Application Reference: 2025/0981

Site Address: 4 Inkerman Road, Darfield, Barnsley, S73 9ND

Introduction: This application seeks full planning permission for the erection of double detached garage to rear of dwelling

PROPOSED FRONT ELEVATION
SCALE 1:100 @ A3

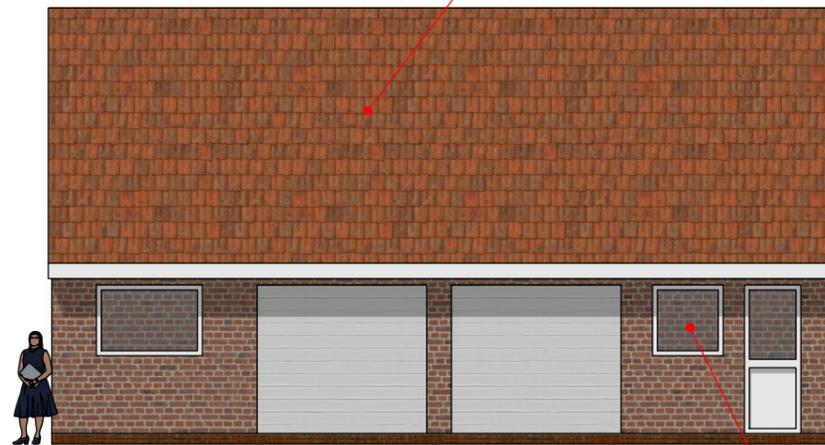
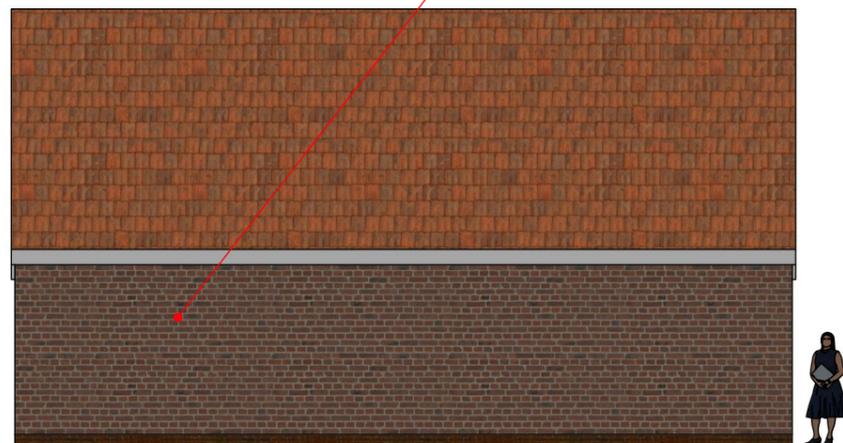
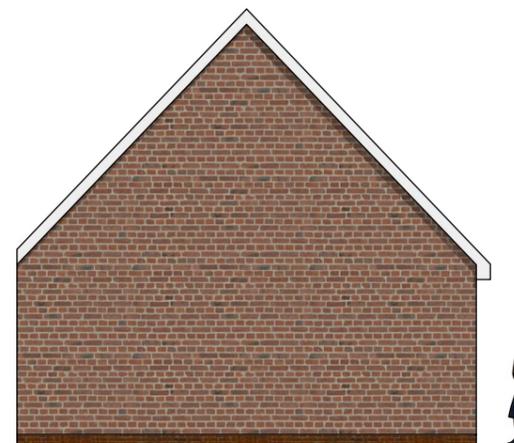
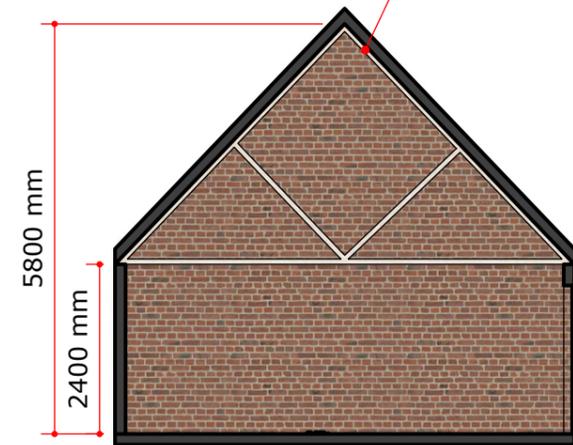
The SPD guidance recommends that a double garage should be 6.5m x 6.5m with an eaves height of 2.5m and maximum roof height of 4m. Following a significant reduction in scale, the

proposed double garage would have dimensions of 6m x 8m, with an eave's height of 2.5m, and maximum ridge height of 4.17m. The footprint of the proposed double garage would be approximately 48 sqm which exceeds the equivalent 42.25 sqm which a 6.5 sqm x 6.5sqm double garage would provide. Whilst the eaves height of 2.5m eaves height remains in accordance with the SPD, the maximum height of 4.17m exceeds the recommended 4m maximum height by 17cm or approximately 6.9 inches, so whilst higher, it would be only marginally higher.

With facing brickwork of a similar appearance to the existing garage, which would be retained, and to an extent similar brickwork to that found in the host dwelling; the proposal would not be visually obtrusive or out of character with the original dwelling or broader street scene.

# SITE PLAN 1:500@A3

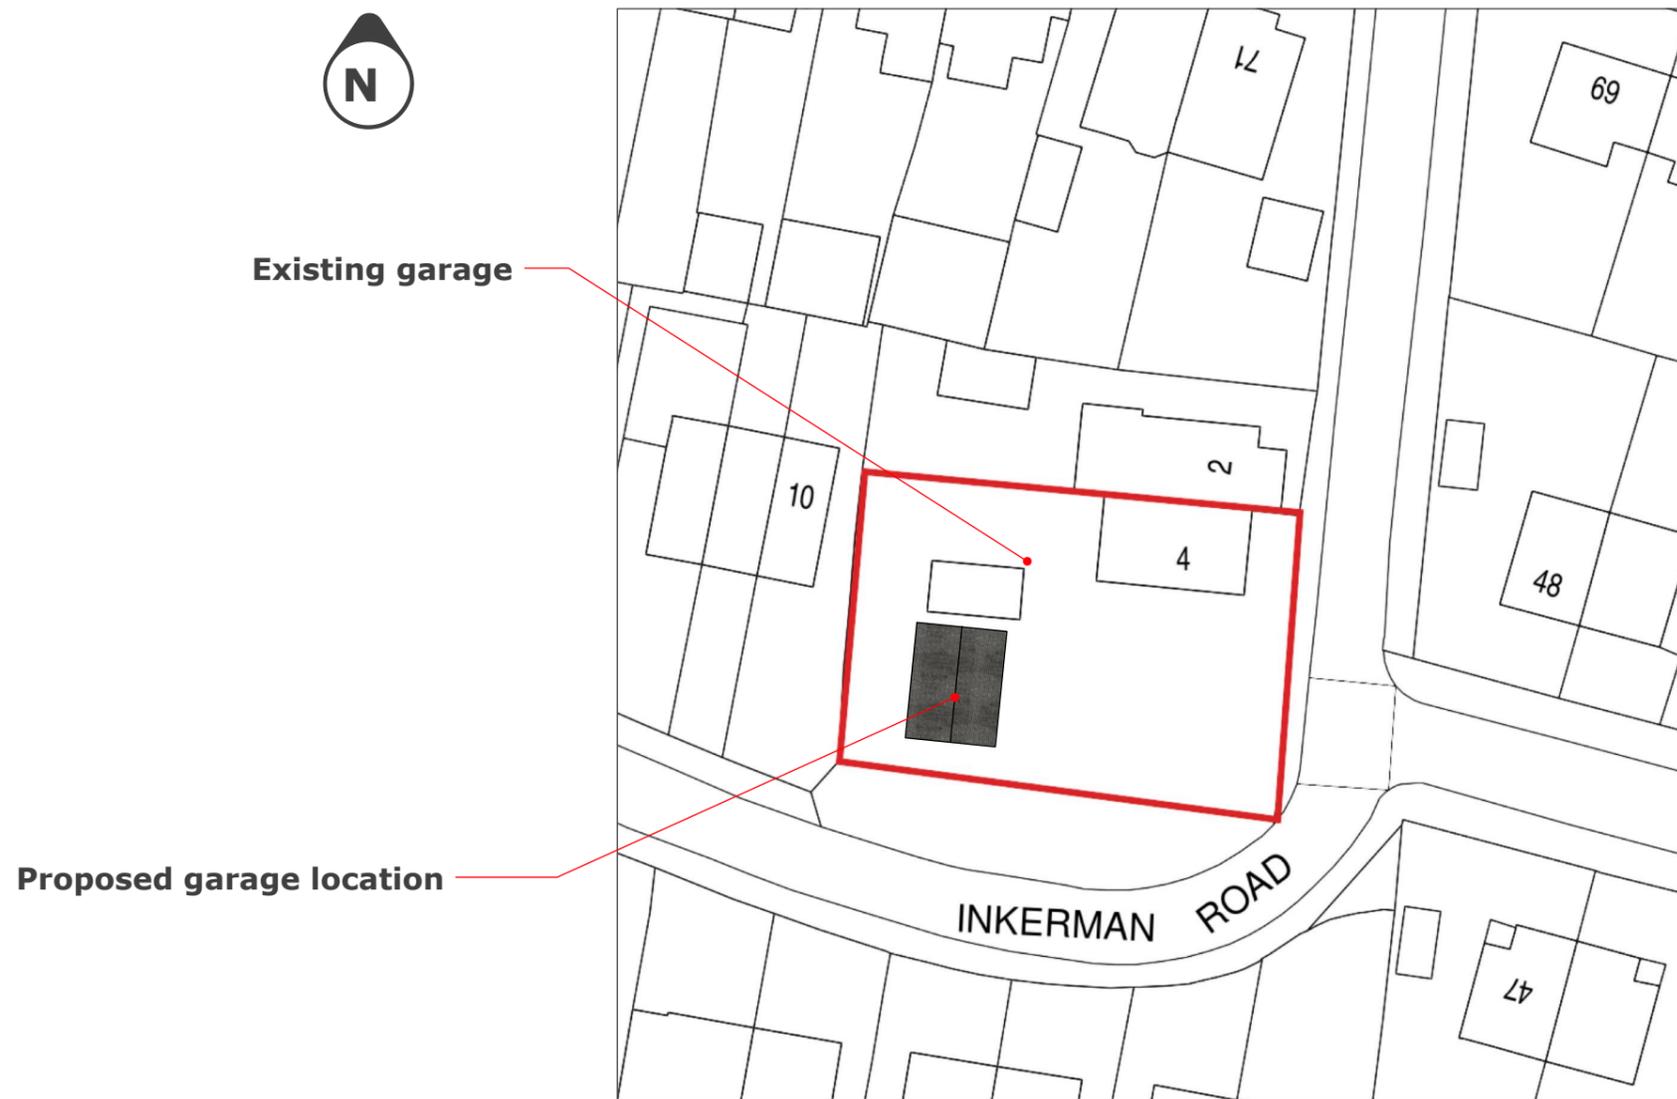
Further mitigation would be the approx. distances between the garage to the boundary treatments of approximately 20m to the front (eastern) boundary, 5m to the rear (western) boundary with No 10 Inkerman Road, 10m to the (northern) side boundary with No 2 Inkerman Road, and 2.5m to the (southern) side boundary, which due to bordering a grass verge would be extended to around a 10m distance between the garage and the actual highway.
